CITY OF ALBUQUERQUE

September 17, 2012

**Re: Paradise Bakery
Grading and Drainage Plan
Engineer's Stamp dated 8-29-12 (A14/D006)**

GRADING AND DRAINAGE PLAN

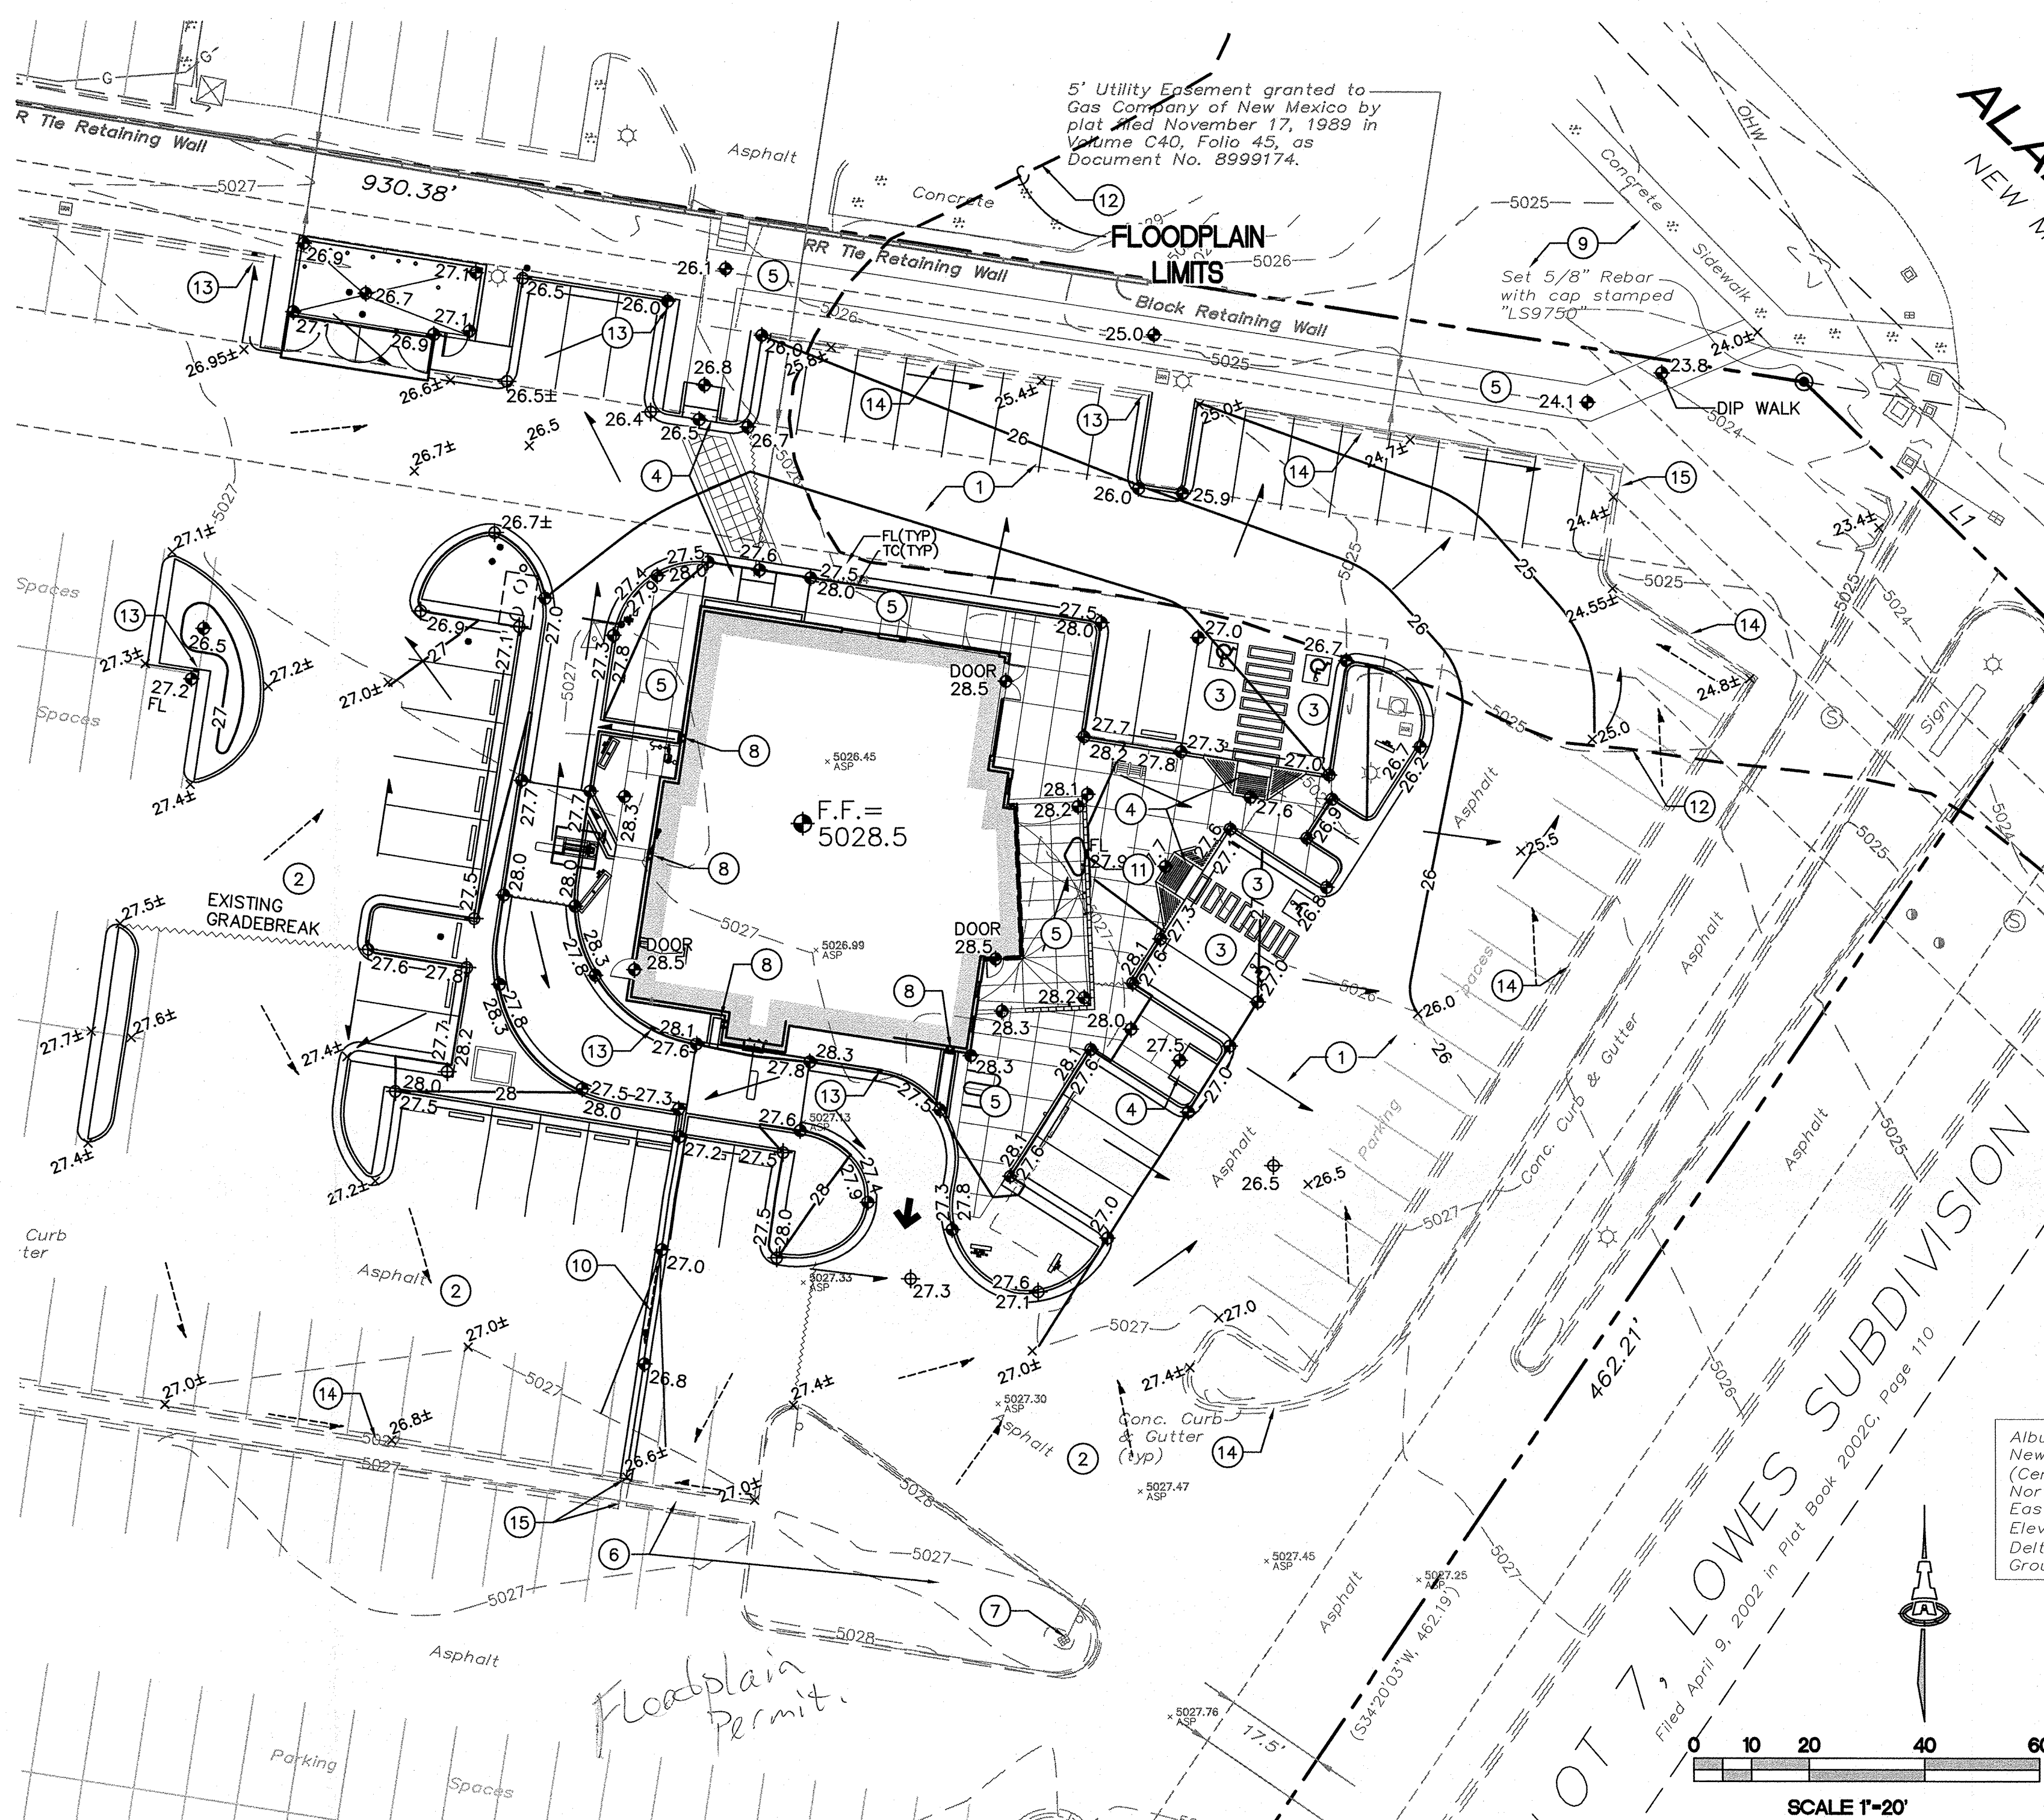
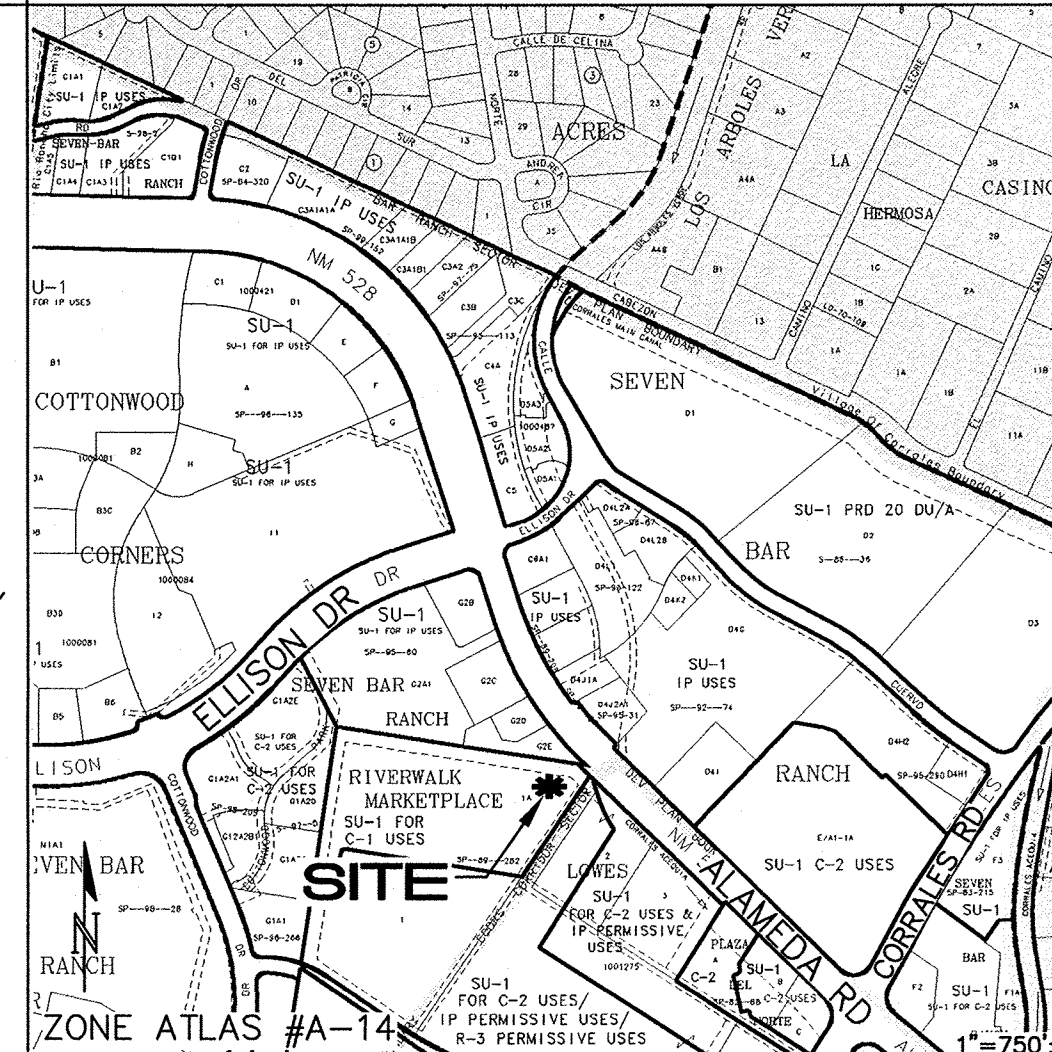
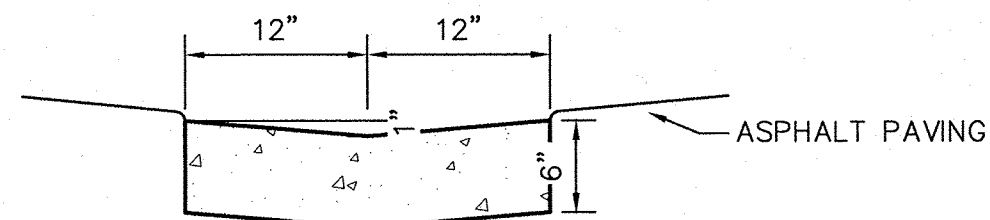
- A floodplain permit is required.

Hydrology is requesting that all proposed landscape areas are depressed to retain/infiltrate the moisture that falls on them.
